Householder Application for Planning Permission for works or extension to a dwelling

single storey rear and side extension, extension of roof to form loft conversion with side dormers and front porch

6/2023/2089/HOUSE

Proposal proposed layouts and elevations

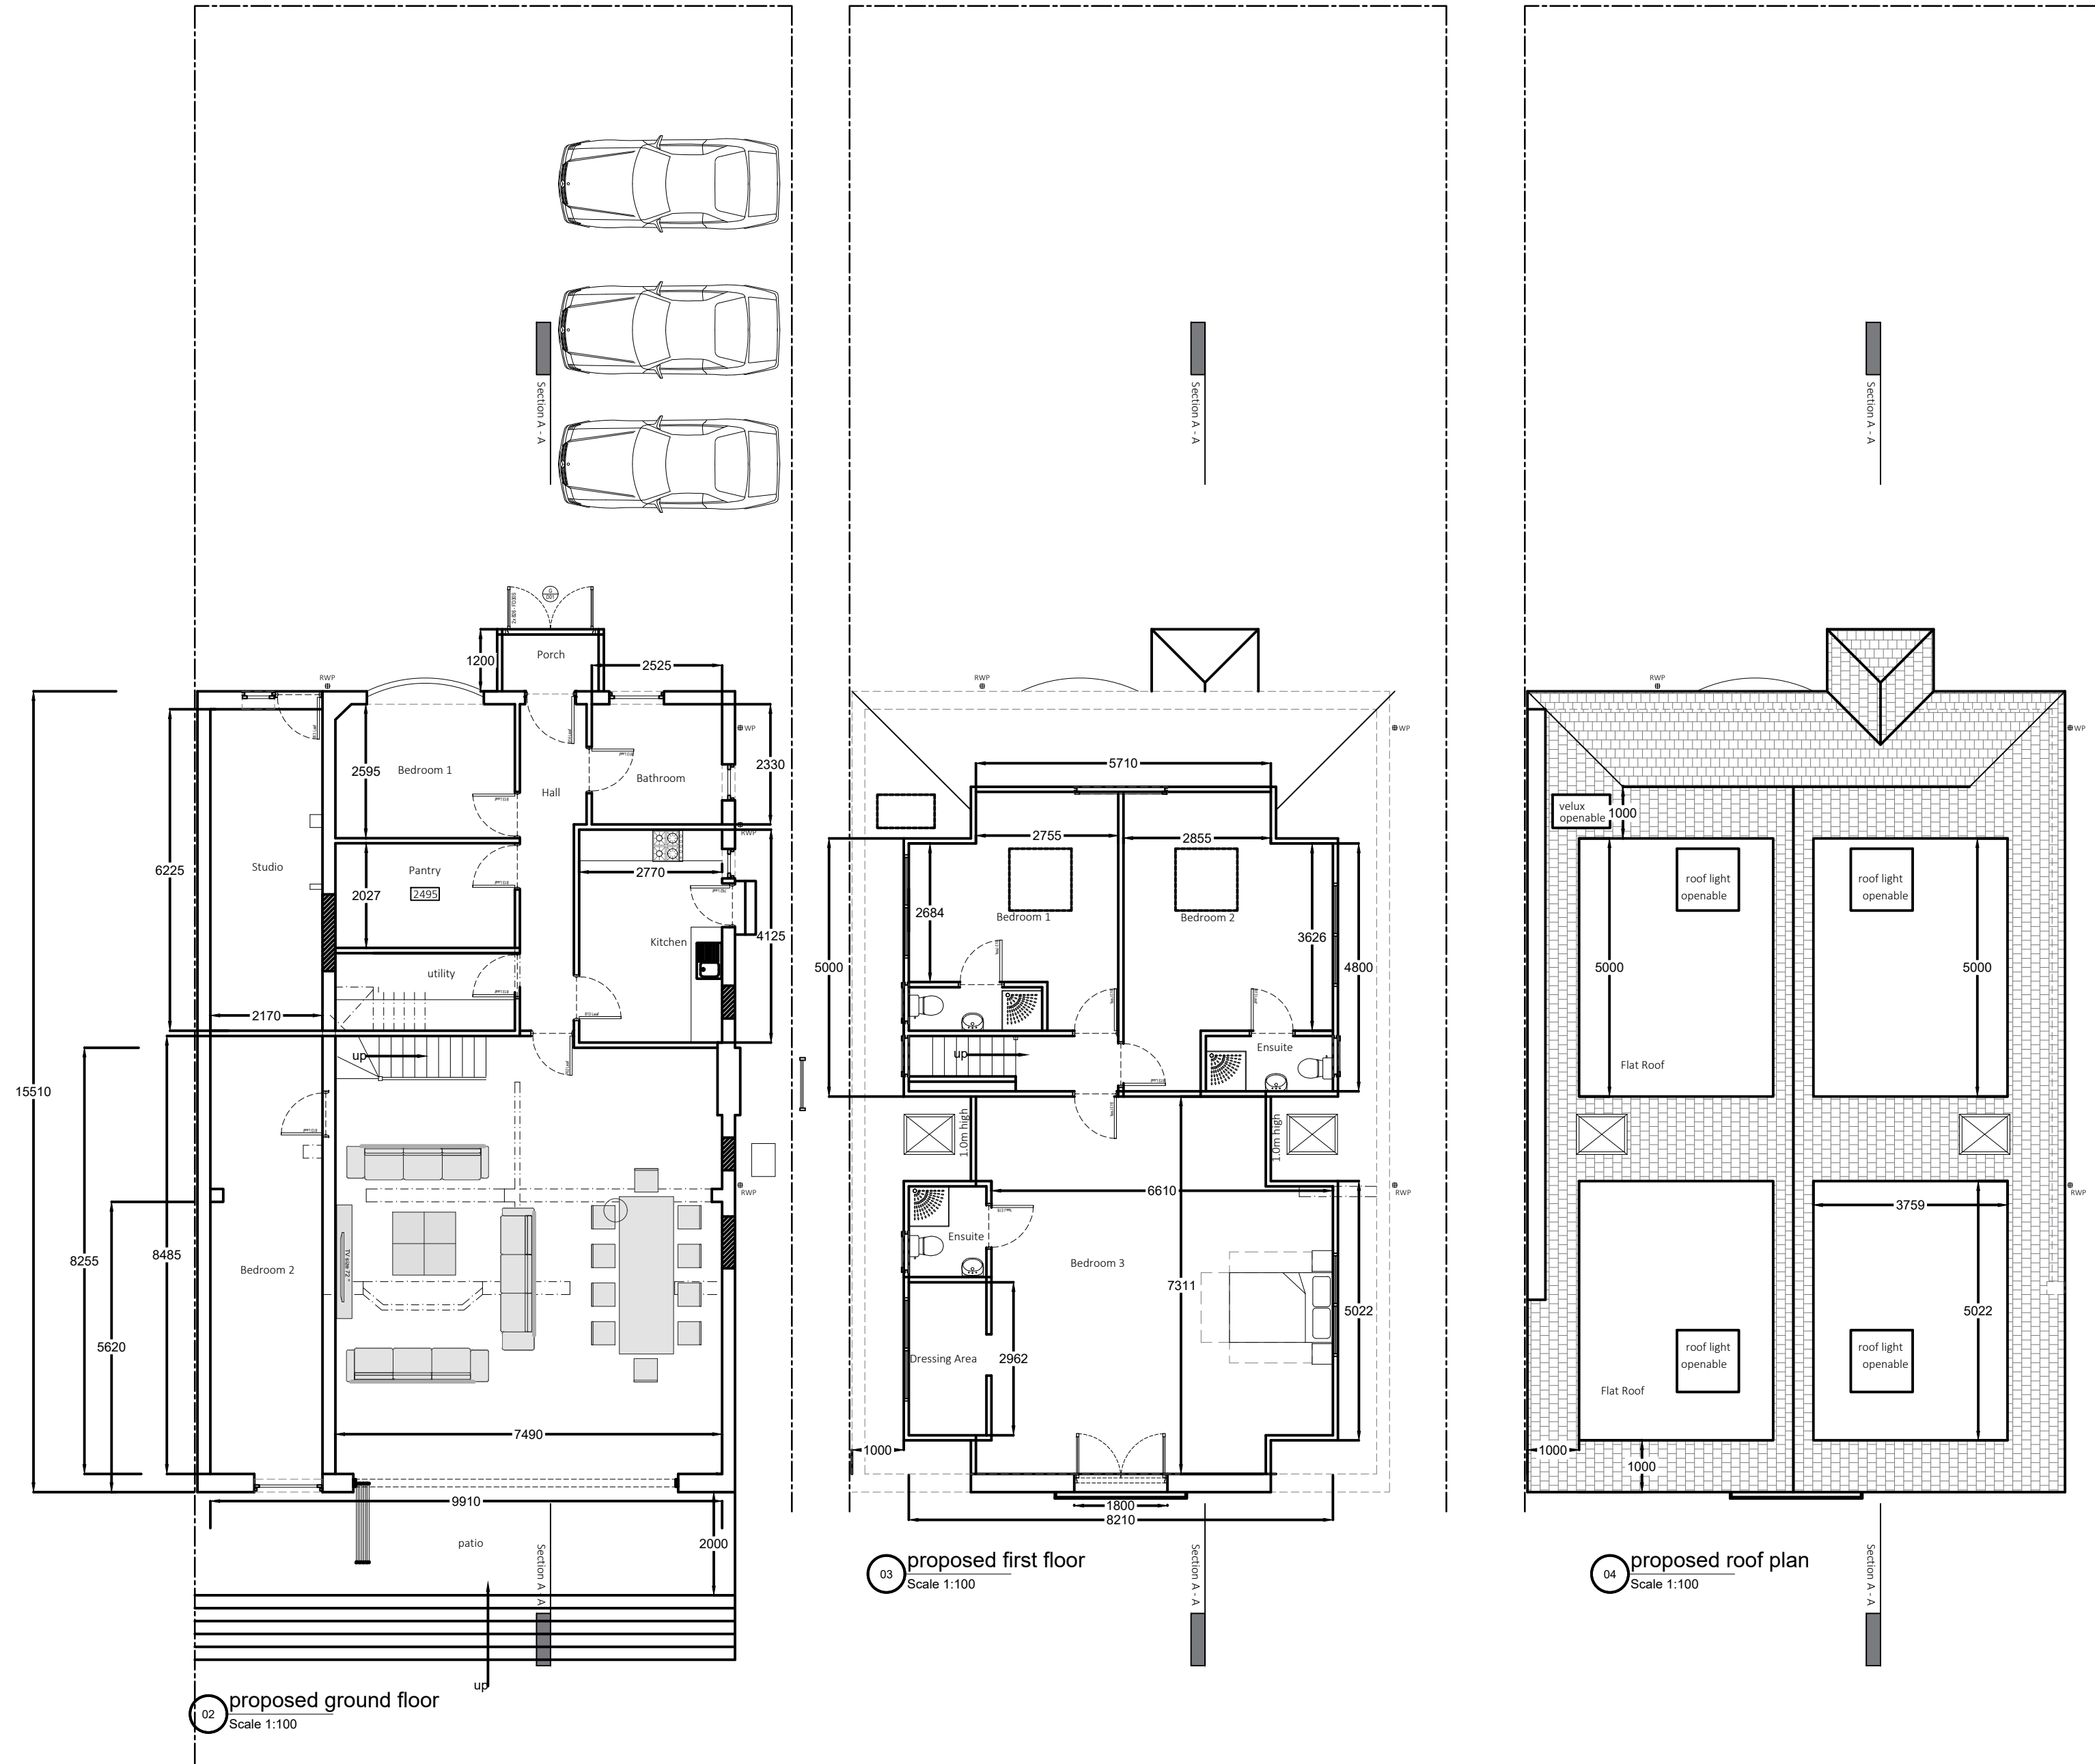
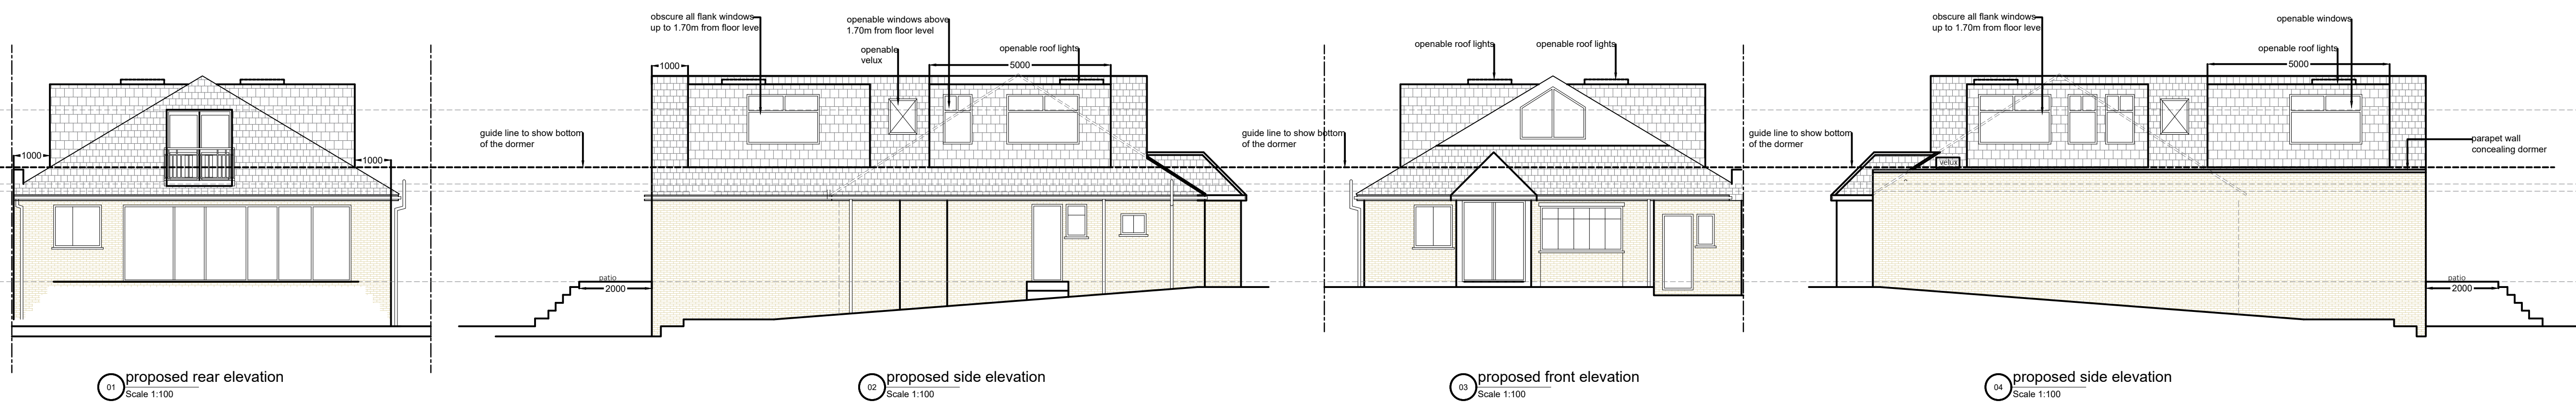
The Council's Supplementary Design Guidance (SDG) states that new dormer windows should be contained within the roof slope, be subservient to the roof of the property and be in proportion to the existing fenestration of the property. They must not extend above the ridge height of the existing dwelling and the dormer cheeks should be at least 1m from the flank wall of the property or of the party wall with the adjoining property. Some of the dormers are set in less than 1 m from the flank wall. Can you please make sure that all the dormers are at least 1m from the flank wall.

The proposed side dormers are set down from the ridge height, however they are large in terms of their coverage across the roof slope. The surrounding area is predominantly characterised by bungalows, some of which have now been extended in the loft space to create habitable accommodation at first floor. Due to this, large side dormers are not an uncommon feature on the road. Therefore, it is considered that the proposed large dormers would not harm the character and appearance of the streetscene in this instance.

The proposed front porch would be limited in depth and height with a pitched roof that complements the host dwelling, this would be acceptable.

In terms privacy, the neighbouring properties at No 39 and 43 Northaw Road East likely to be impacted by the side dormer windows. Whilst some of the side windows are marked as obscure glazed and fixed below a height of 1.7m above floor level, to prevent loss of privacy to neighbours all side windows at first floor should be obscure glazed and fixed below a height of 1.7m above floor level.
